DRAINAGE LETTER
FOR
STERLING RANCH RECYCLING FACILITY

June 2022
Project No. 25188.00
PCD Filing No:

Please update with
"PPR-22-041"

PRE-DEVELOPMENT DRAINAGE MAP

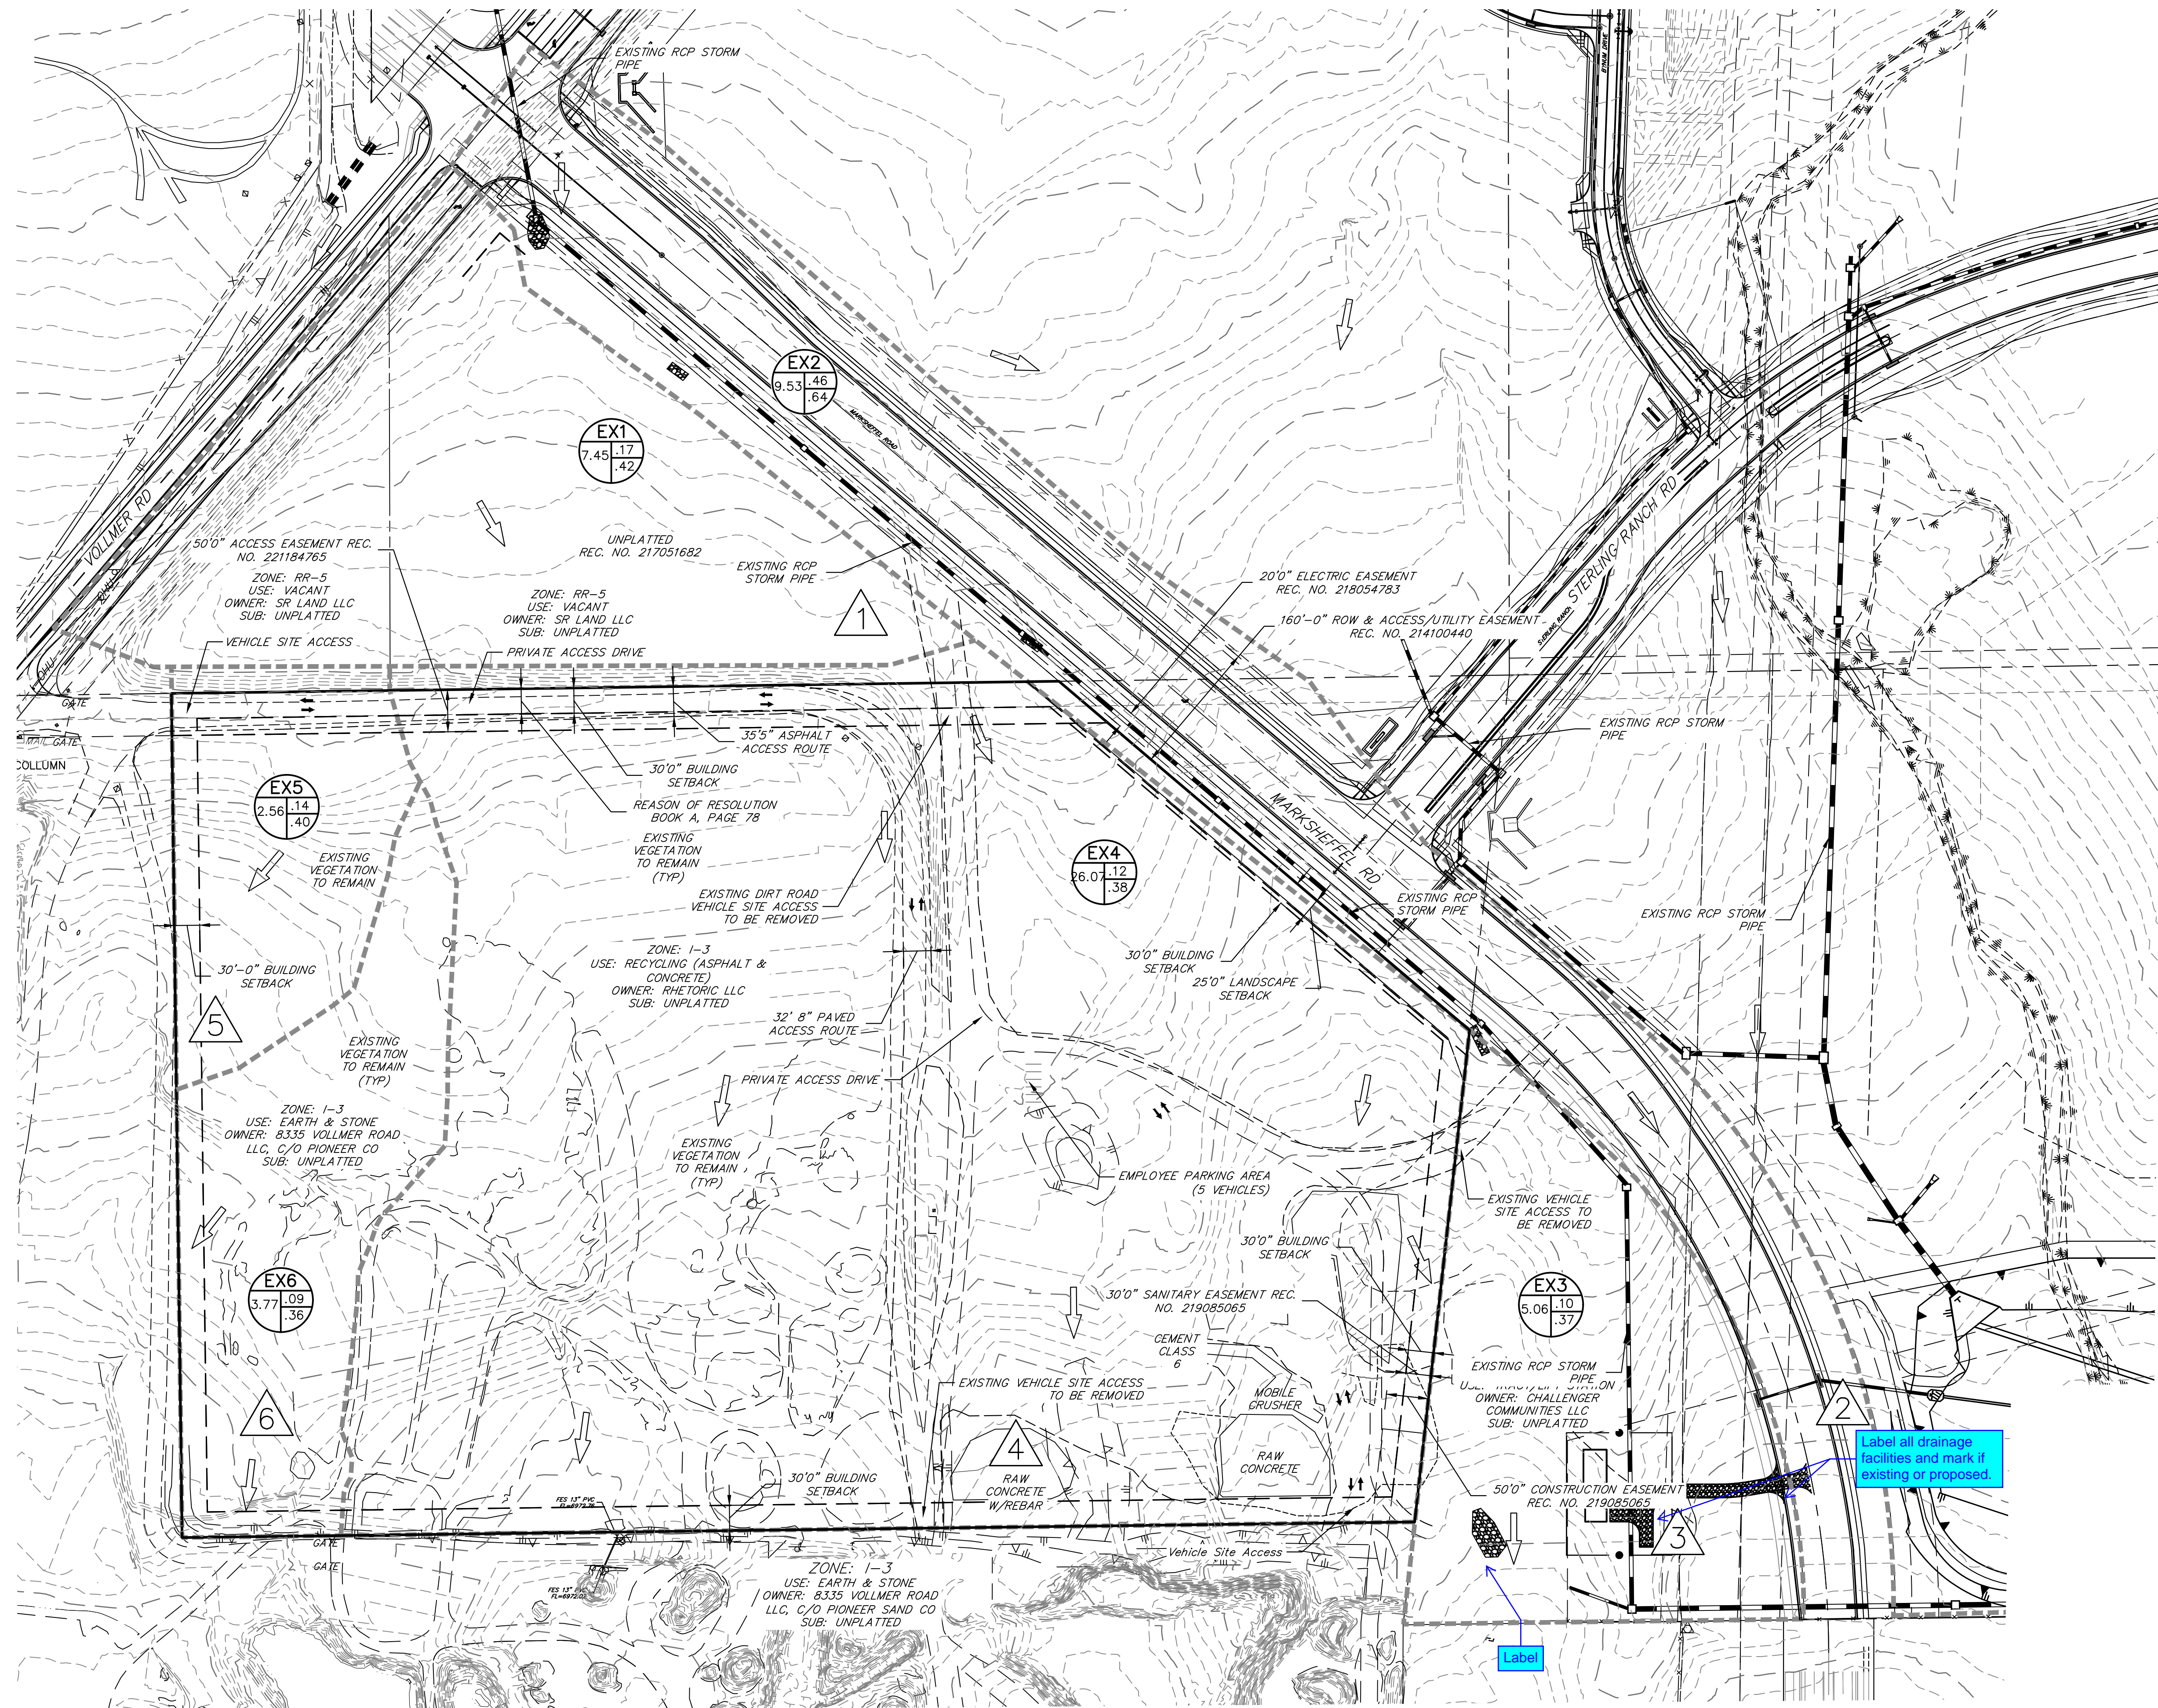
pre-development

JR Response: addressed.

STERLING RANCH RECYCLING FACILITY  
 EXISTING DRAINAGE MAP  
 JOB NO. 25188.00  
 06/03/22  
 SHEET 1 OF 1

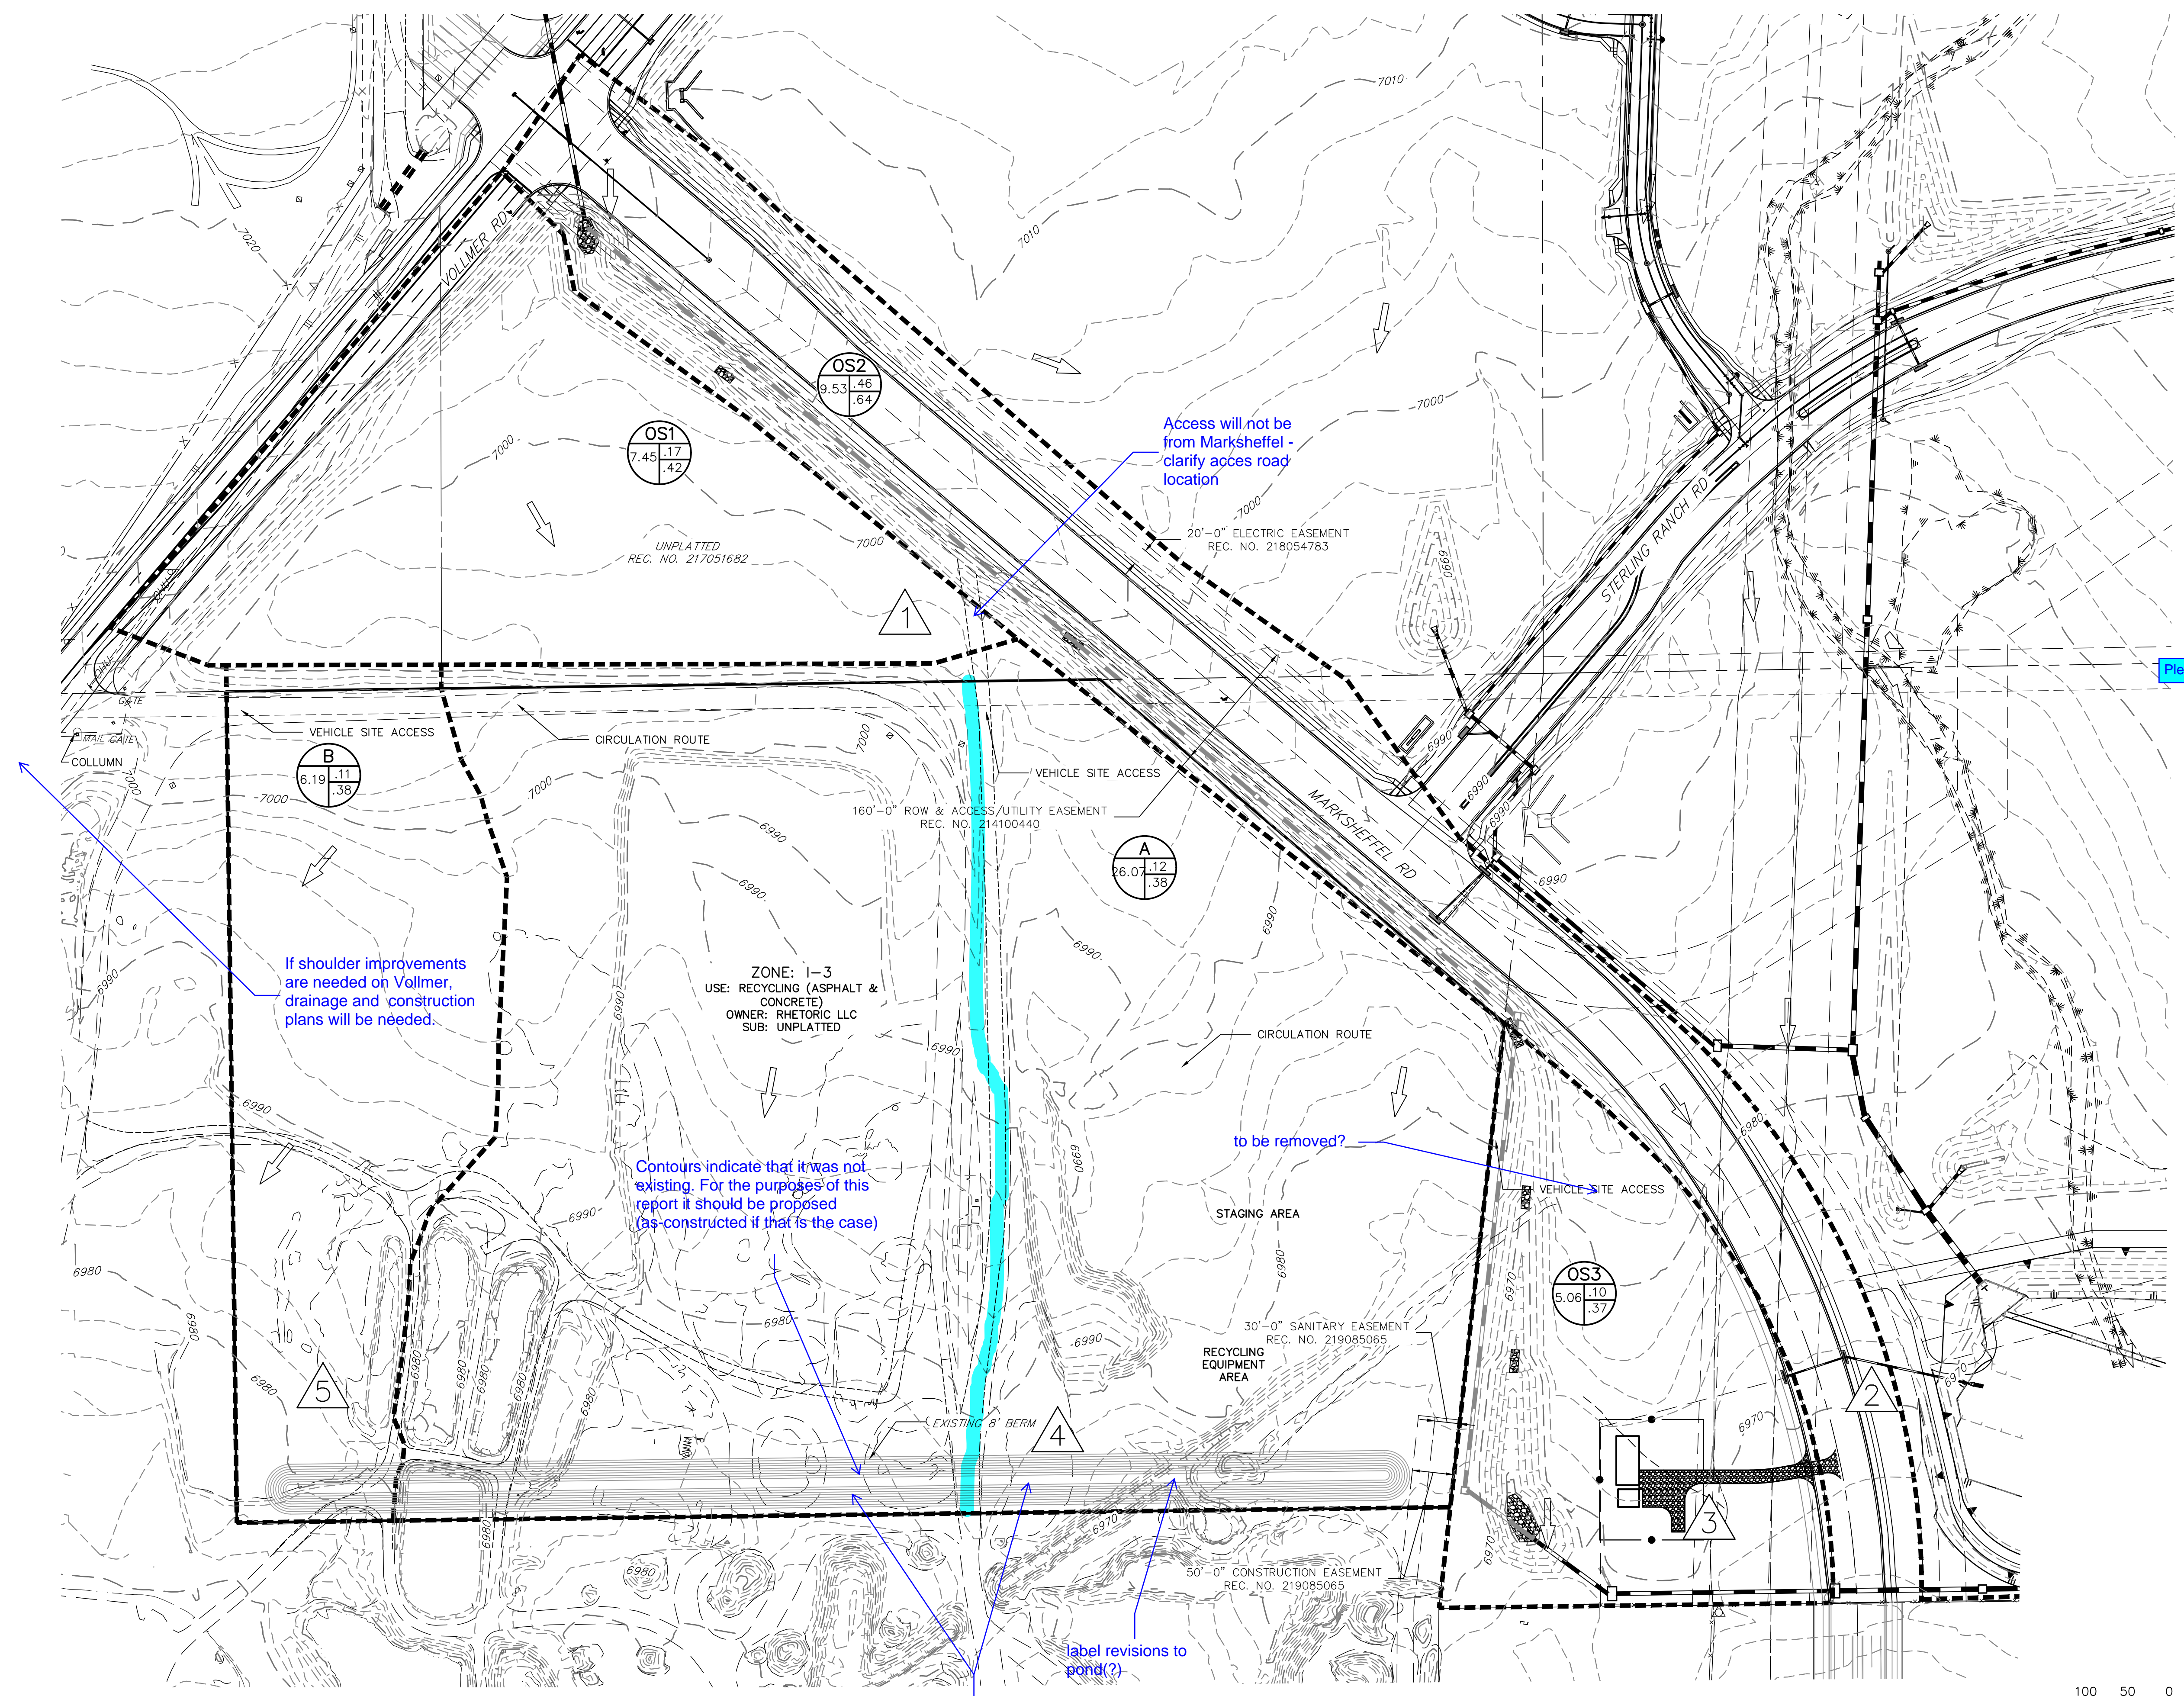
Hydrological calculations and drainage map show the area of EX5 being 6.19 acres. Please revise if necessary.
